## MEADOW LAKE INDUSTRIAL PARK REZONE

CS – Commercial Services and I-2 Limited Industrial to GA-O – General Aviation Overlay  
[Meadow Lake Airport]

### LETTER OF INTENT

SHEET TITLE:
GENERAL AVIATION OVERLAY

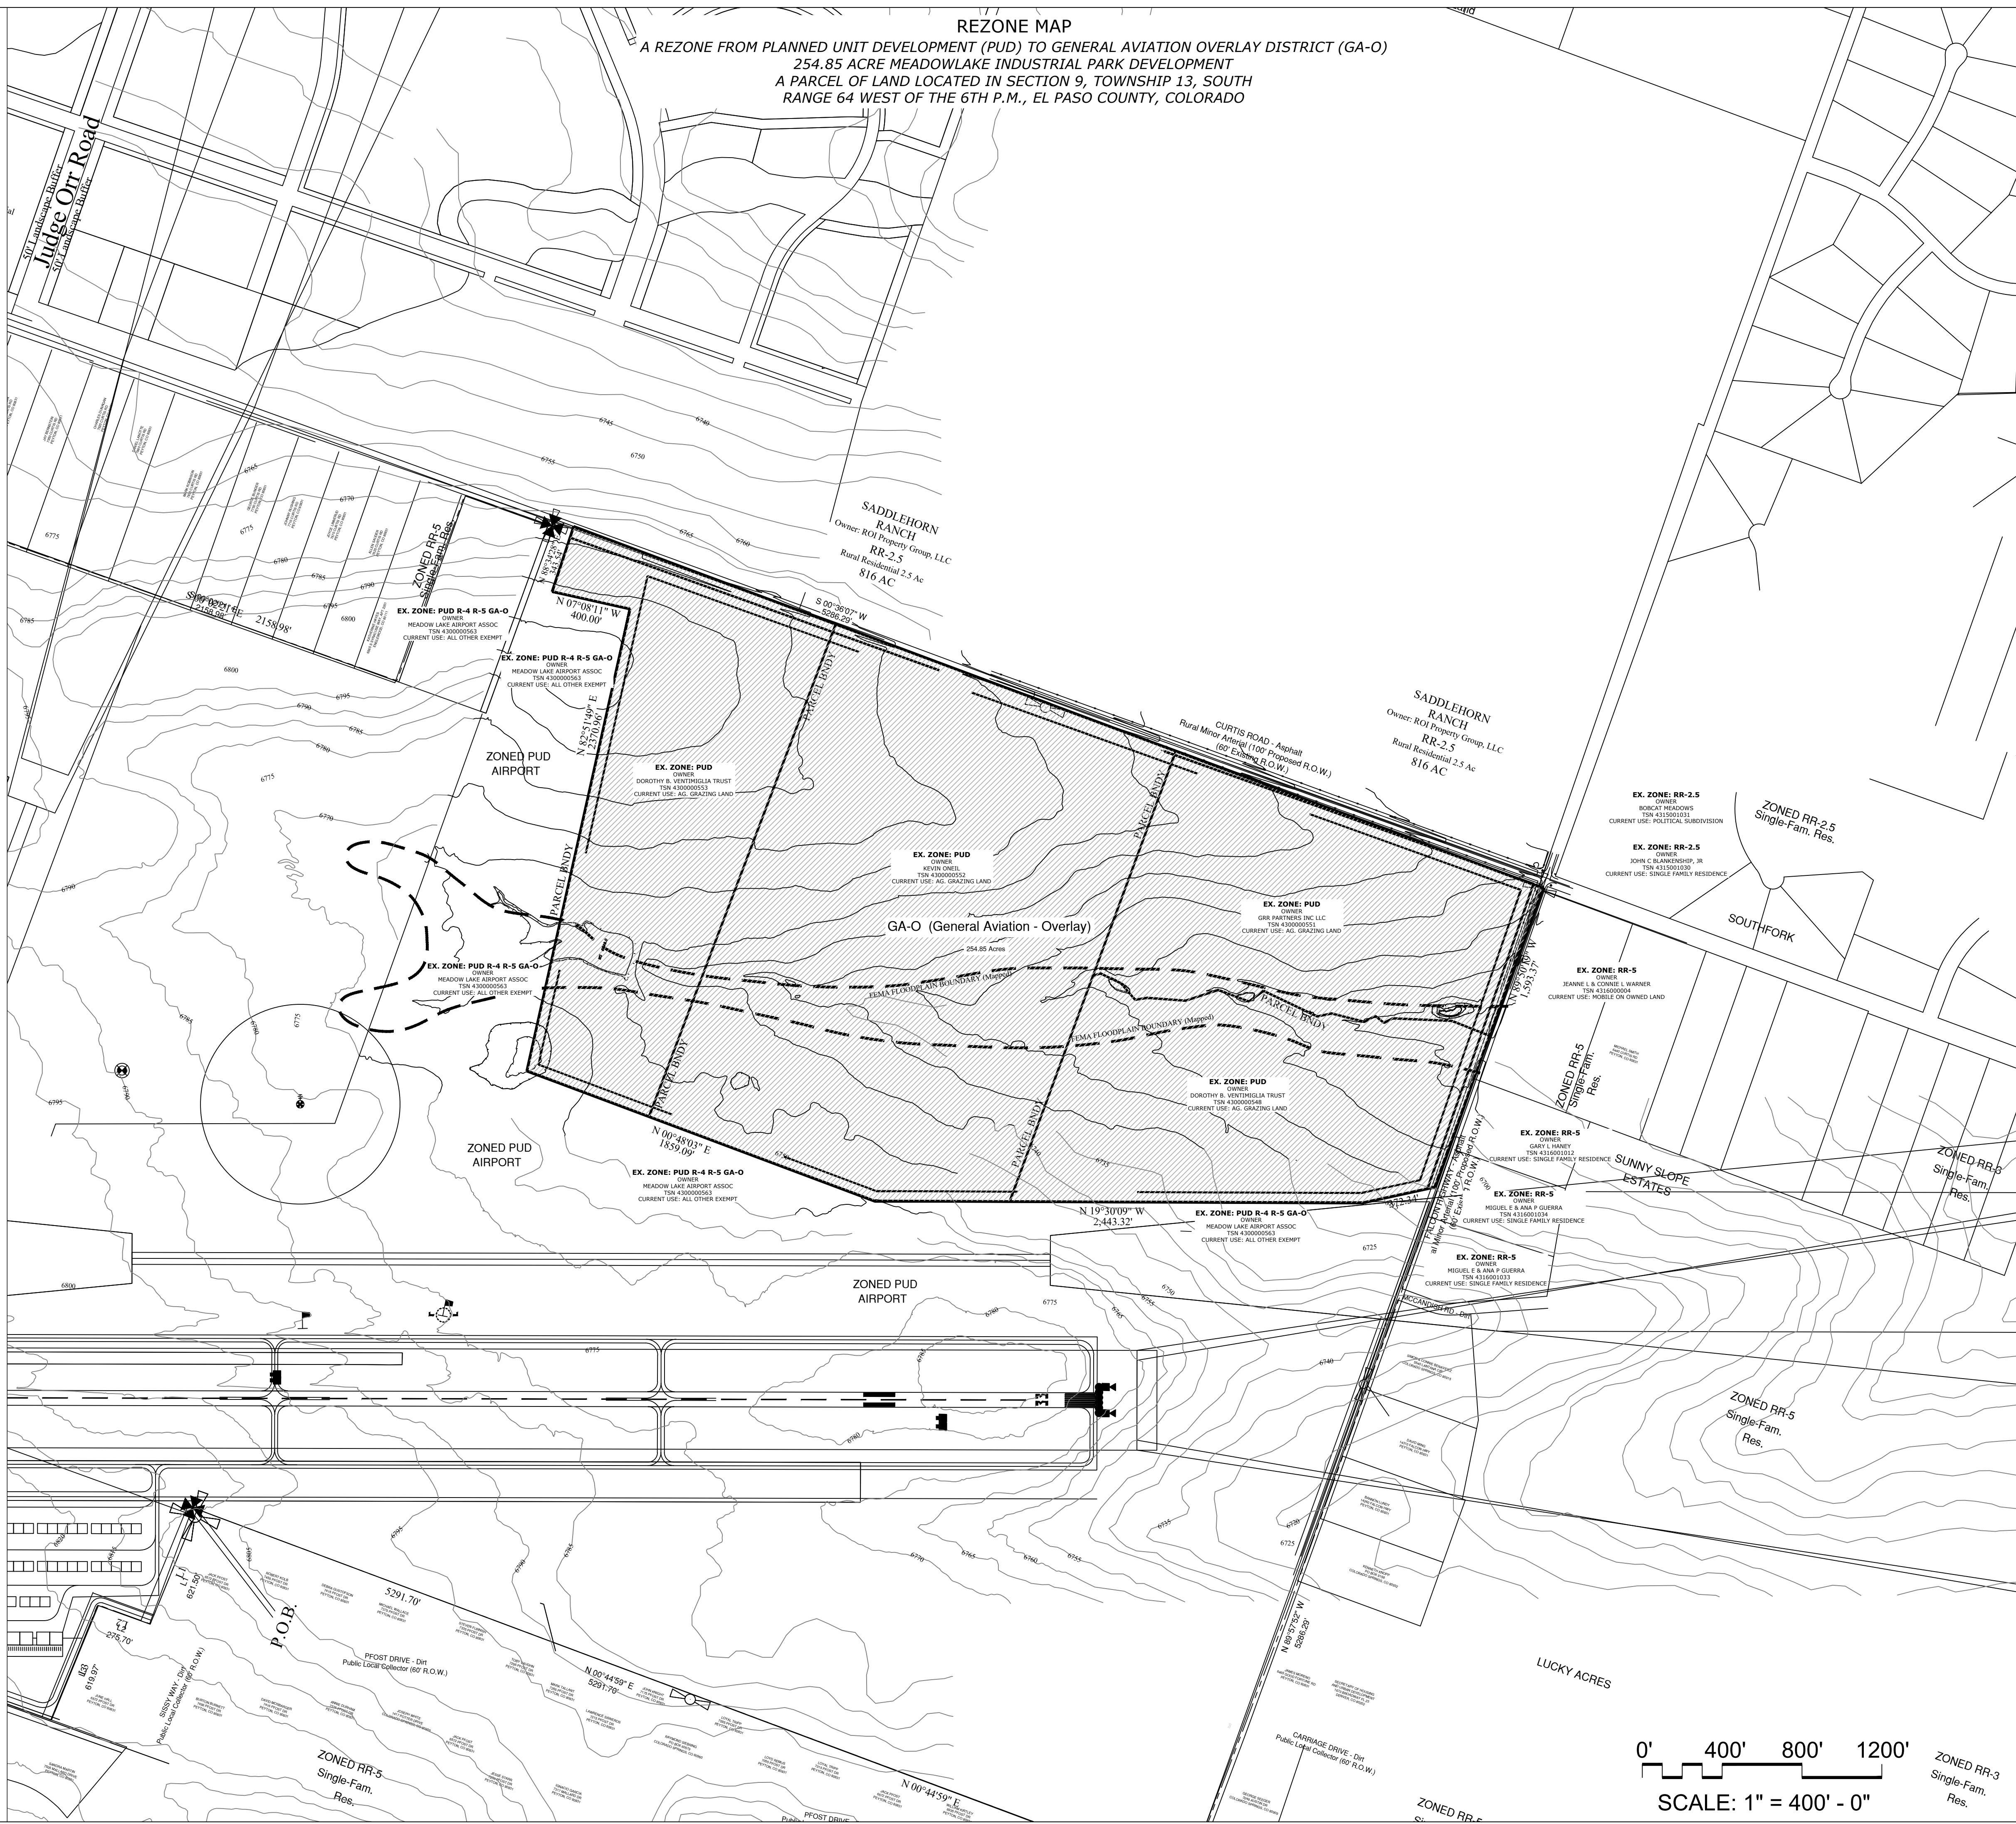
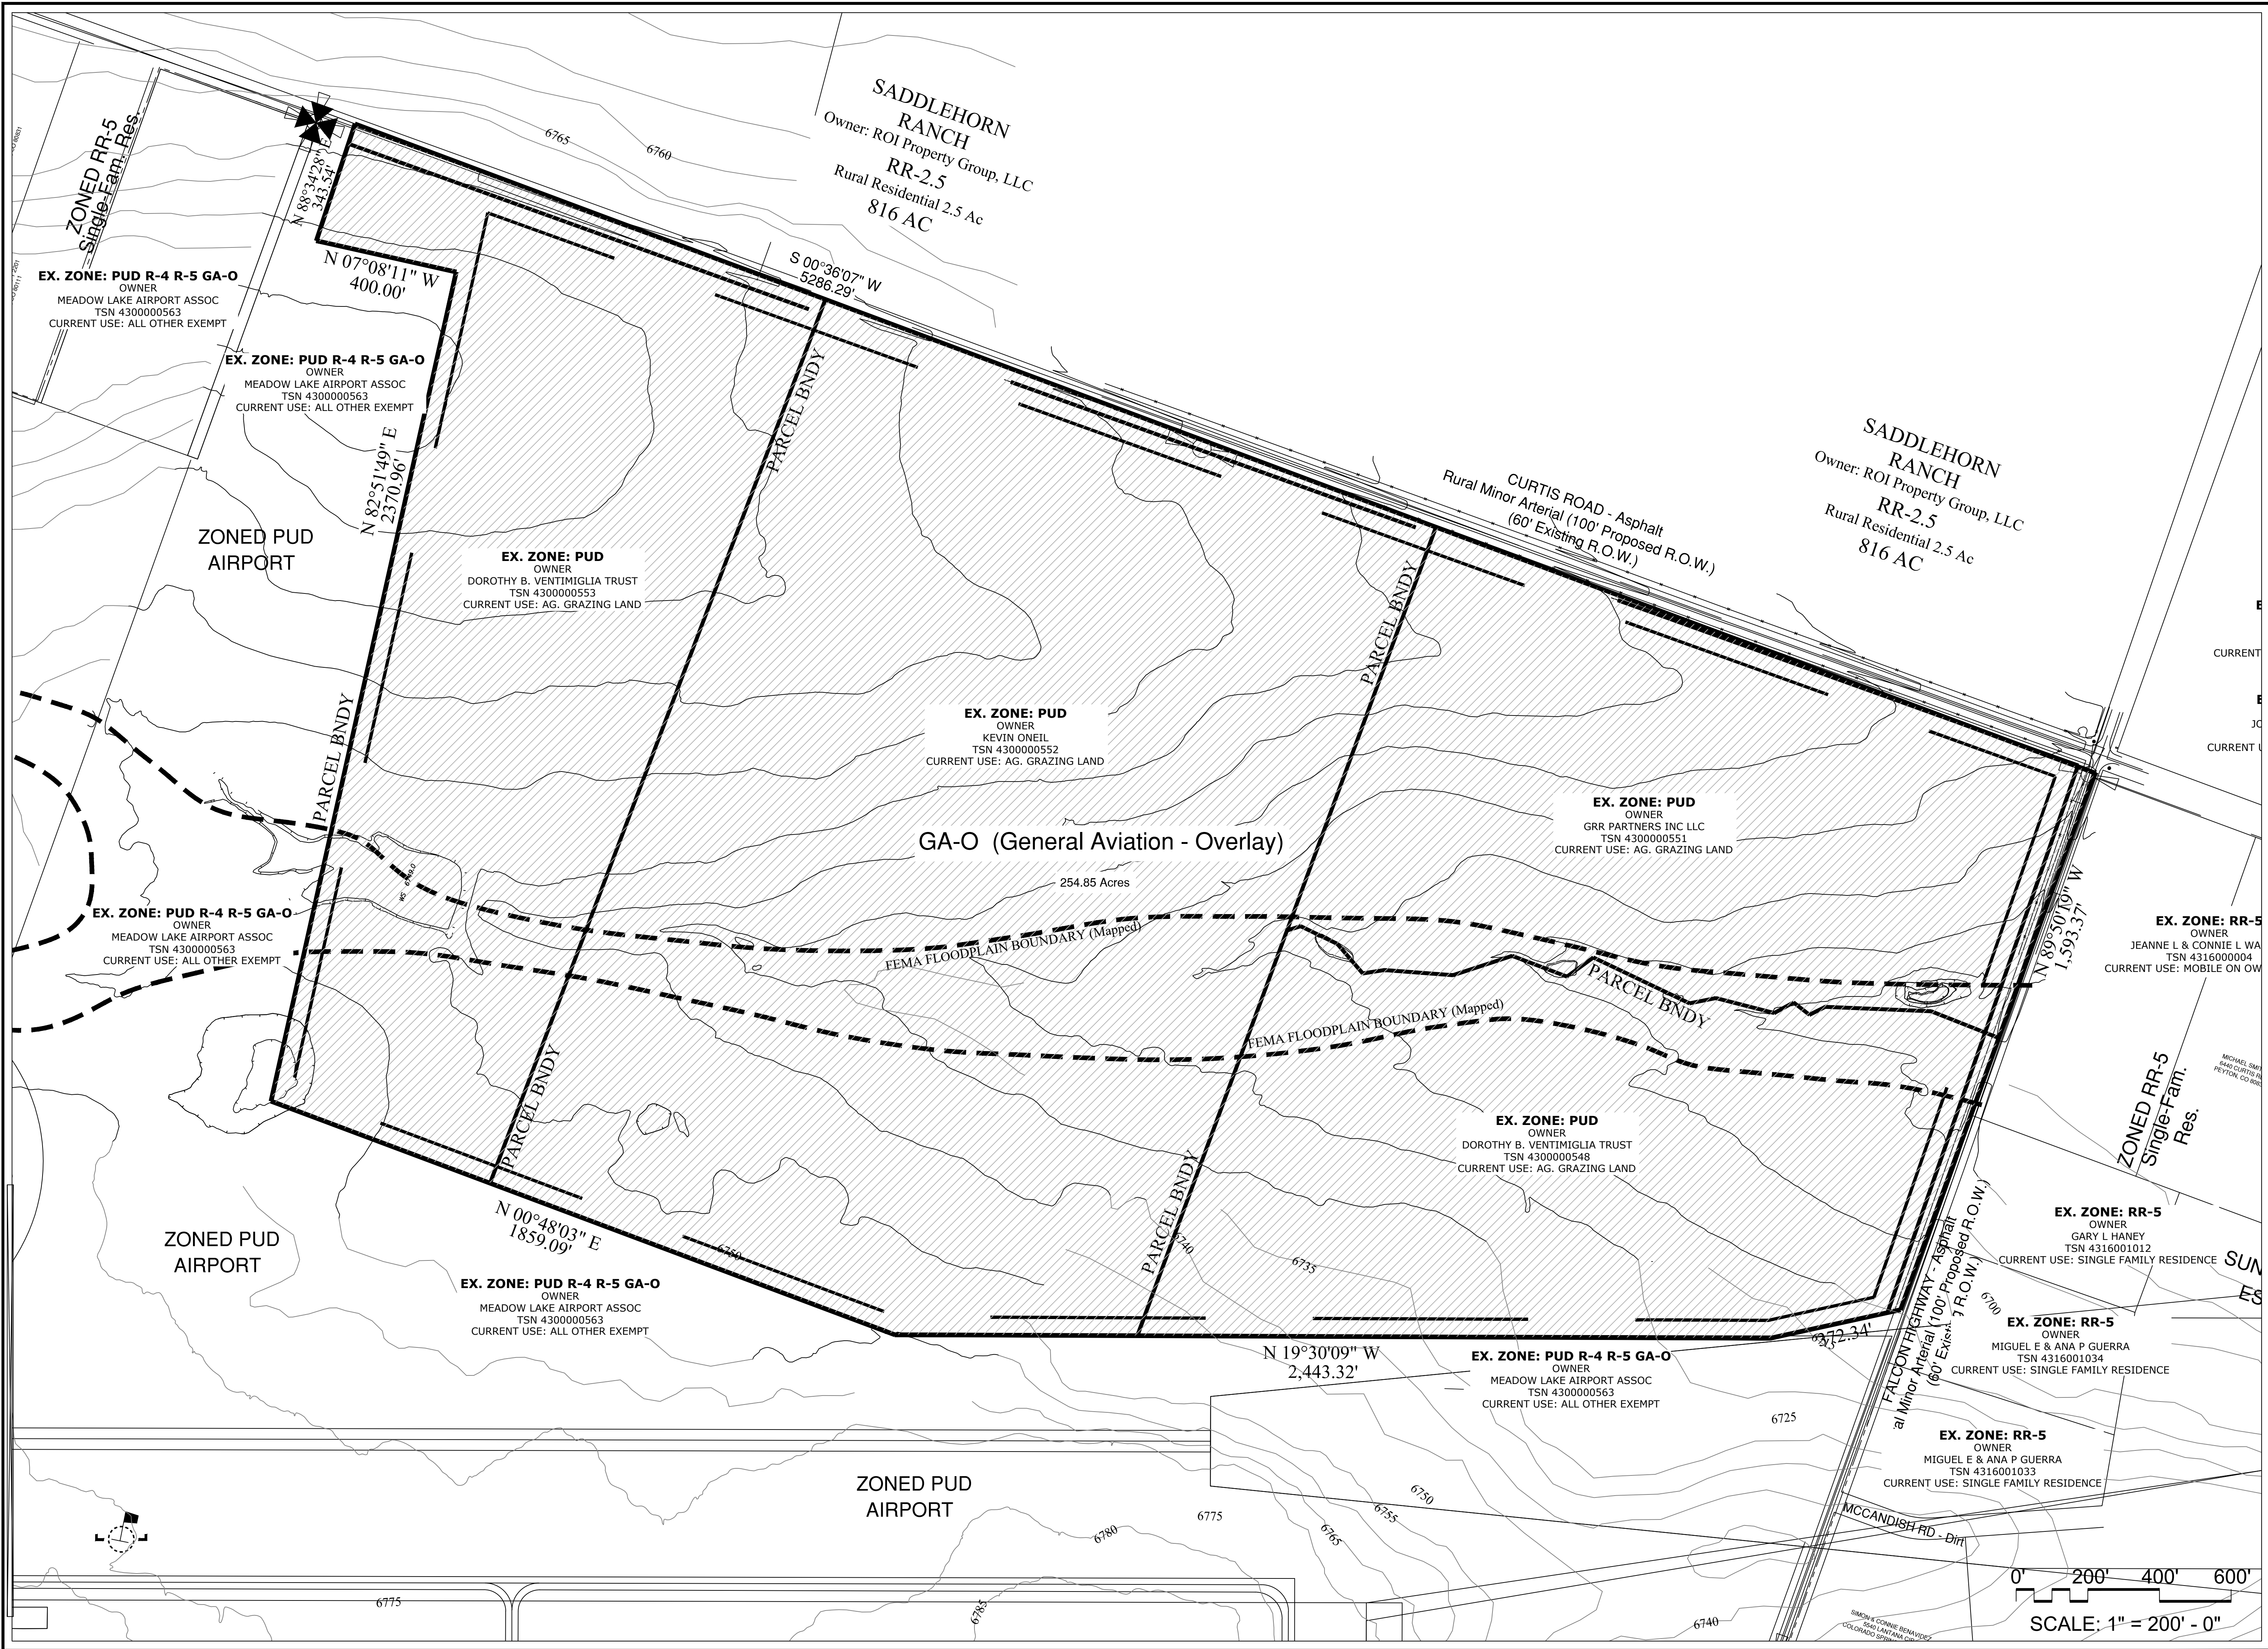
The MTCP indicates Curtis as a Principal Arterial (180' ROW). Please revise.
